Application Ref:	3/2025/0899				Ribble Valley Borough Council www.ribblevalley.gov.uk
Date Inspected:	N/A	Site Notice:	N/A		
Officer:	KH				
DELEGATED ITEM FILE REPORT:					REFUSAL

Development Description:	Prior notification for proposed single storey rear extension 8m long and 3.76m high (max) under Part 1 Class A of the GPDO.
Site Address/Location:	Woodfold Park Stud, Woodfold Park, Mellor BB2 7 QA

**Proposed Elevations**

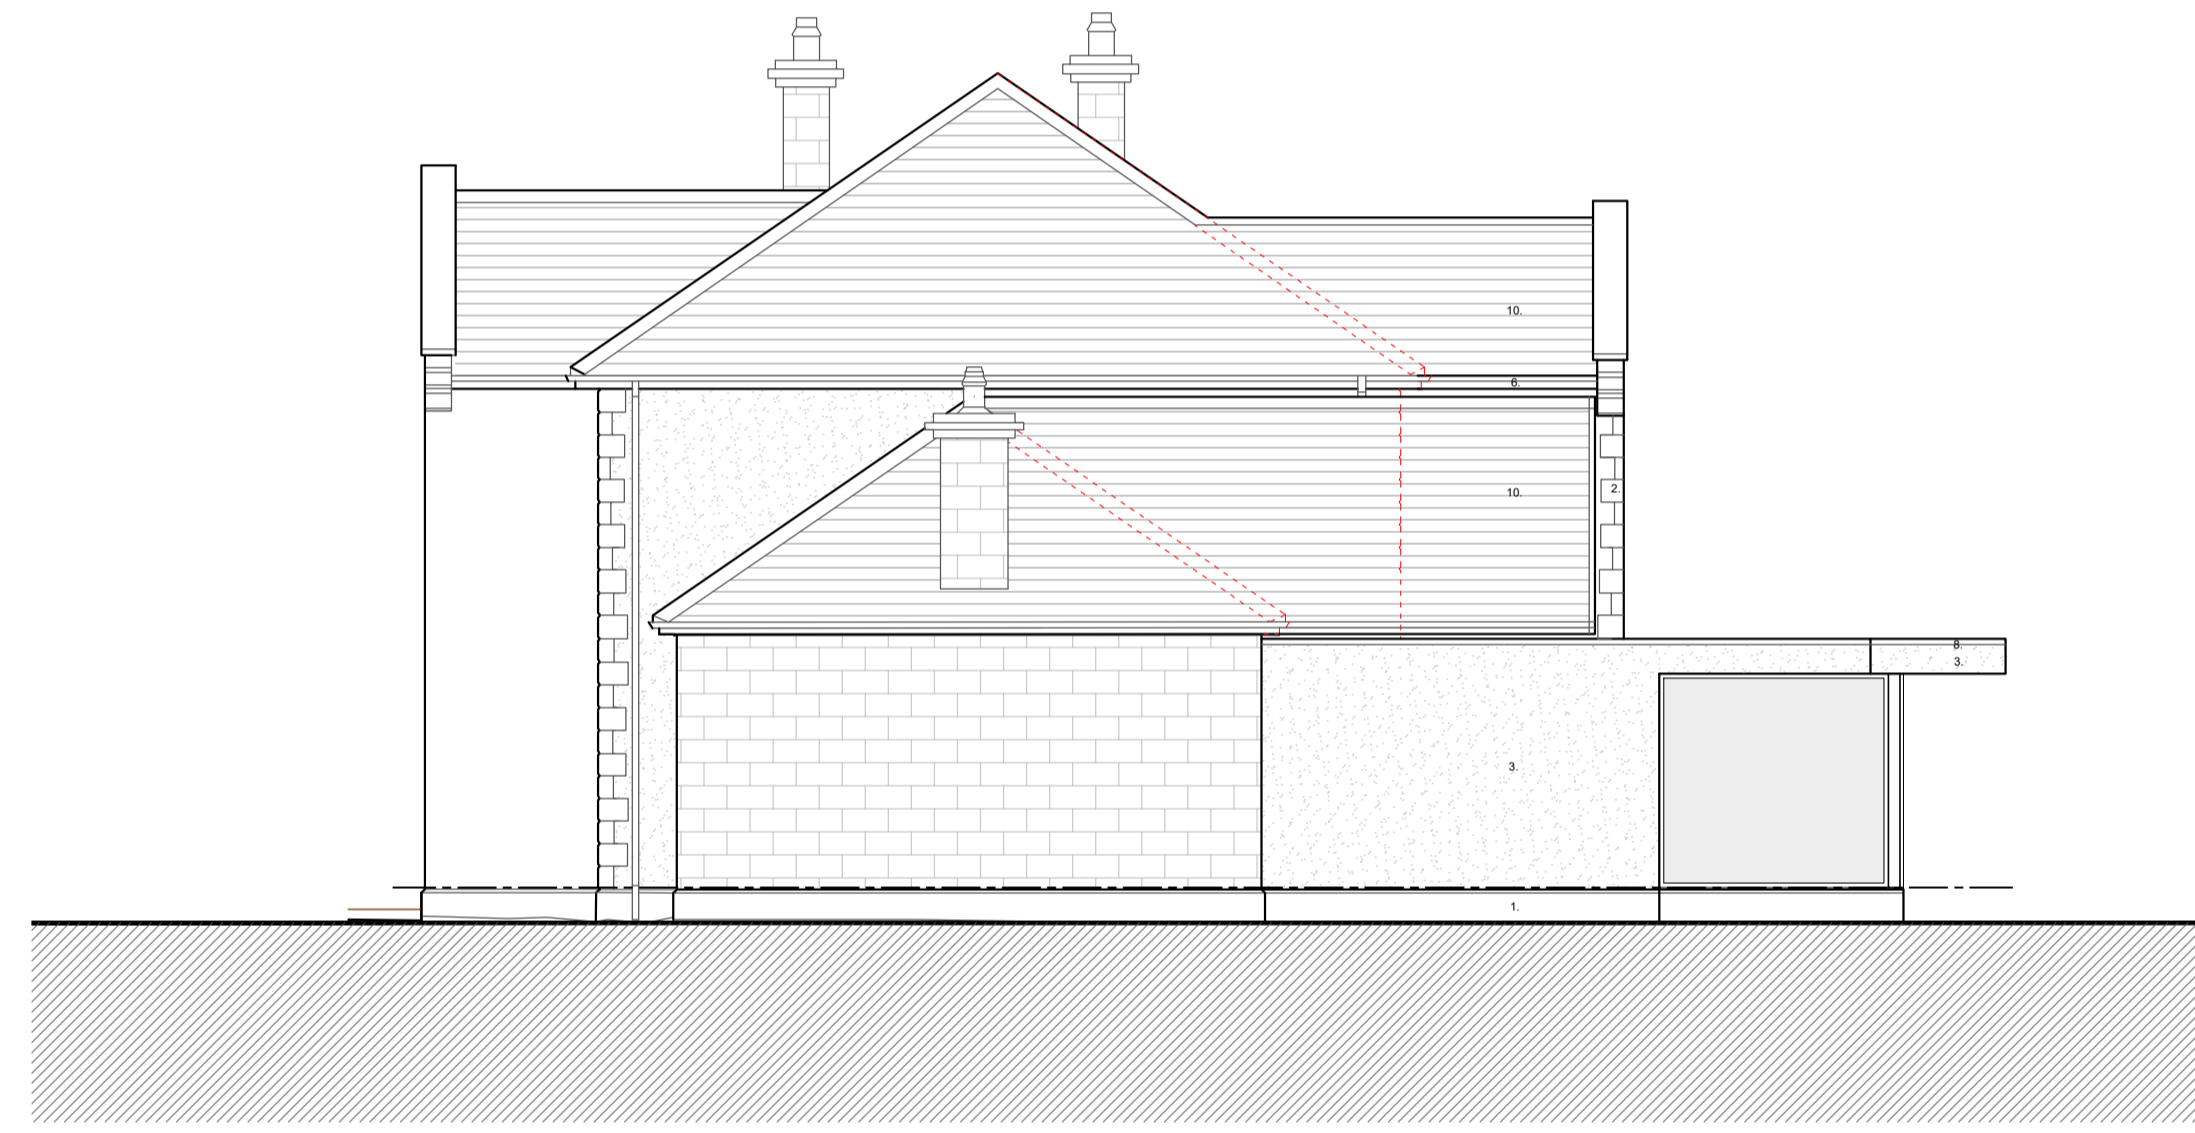
The proposed single storey extension would extend beyond the rear wall of the original detached dwellinghouse by more than 8 metres and would measure 3.76 metres in height to the ridge. Whilst the 8m can be staggered in line with the rear projections, however, measurements of the extension beyond the rear wall should be made from the base of the rear wall of the original house to the outer edge of the wall of the extension. Where the original rear wall is stepped, then each of these walls will form 'the rear wall of the original dwellinghouse'. In such cases, the limits apply to any of the rear walls being extended beyond.

In this case the proposed plans show an 8m rearward projection from the central rear wall of the dwellinghouse as well as an 8m projection from the eastern and western rear walls. However, the extension will not extend beyond the central rear wall of the original dwelling, with the intention being to demolish this section of original wall and infill the area between that wall and the proposed extension with a two-storey extension. Therefore as the proposed extension would not extend beyond the original wall at this point then this wall cannot be used to define the 8m projection. Instead, the proposed extension would extend beyond the western rear wall of the original dwelling, and the LPA's view is that this is the rear wall where the projection should be calculated, and the projection would exceed 8m. Therefore, the proposal fails to meet criteria (g)(i).

Due to the staggered rear elevation, the original dwellinghouse has a number of side walls as set out in the National Planning Technical Guidance. The proposed extension would extend beyond a side wall of the original dwelling situated between the central and western rear elevation. Therefore, for the proposed extension to be permitted it would need be limited to a width no greater than half the width of the original dwellinghouse. In this case the extension would extend the full width of the property and therefore fails to meet criteria (j)(iii).
